**APPLICATION BY HIGHWAYS ENGLAND FOR AN ORDER GRANTING
DEVELOPMENT CONSENT FOR THE A47 NORTH TUDDENHAM TO EASTON
PROJECT**

**DEADLINE 7 SUBMISSION: COMMENTS ON DOCUMENT 9.25 ADDITIONAL
ENVIRONMENTAL INFORMATION**

We have reviewed the Additional Environmental Information (Document 9.25) submitted by the Applicant at Deadline 6 [REP6-019]. We would like to provide further comments in relation to Section 5.2, concerning the updated hydraulic flood modelling for the Hockering tributary.

Figure 0.2 Hockering Baseline full flood extent

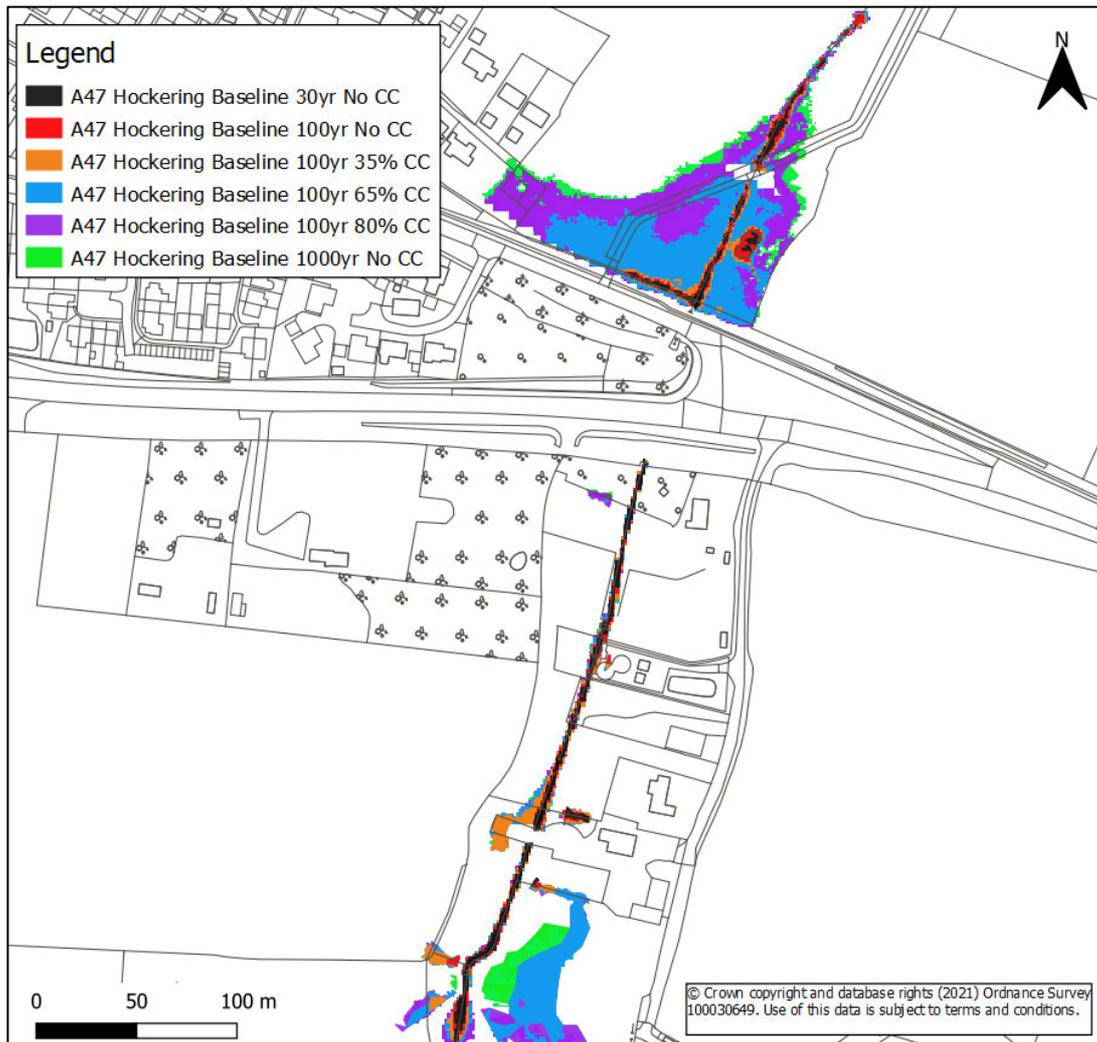
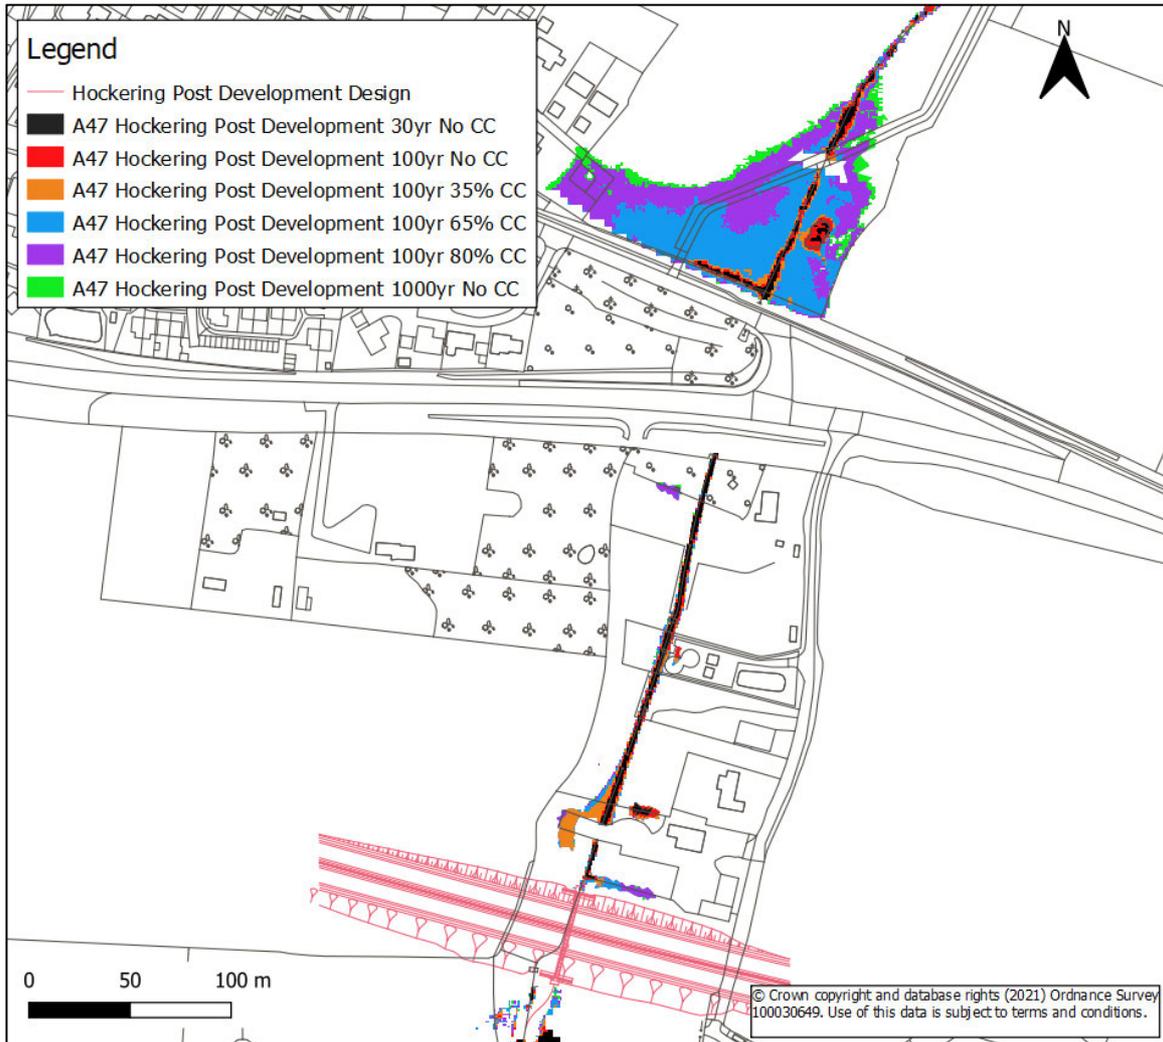
Since Document 9.25 was produced, we have reviewed the revised hydraulic flood model and the modelling report for the Hockering watercourse. We have confirmed to the Applicant that we are satisfied that the report now adequately demonstrates that compensatory flood storage will not be required. We had previously requested further detail on this point [REP4-017]. The report confirms that the impacts of the proposed scheme on flood risk will be negligible, with flood waters mostly staying within the channel.

Regarding the updated Hockering flood model, we have highlighted to the Applicant that there are 3 minor issues with the modelling that remain to be addressed. However, it is our view that those issues are unlikely to result in any significant changes to the assessment of flood risk. We are therefore satisfied that any minor changes to flood risk that may arise from addressing these points can be managed at the detailed design stage.
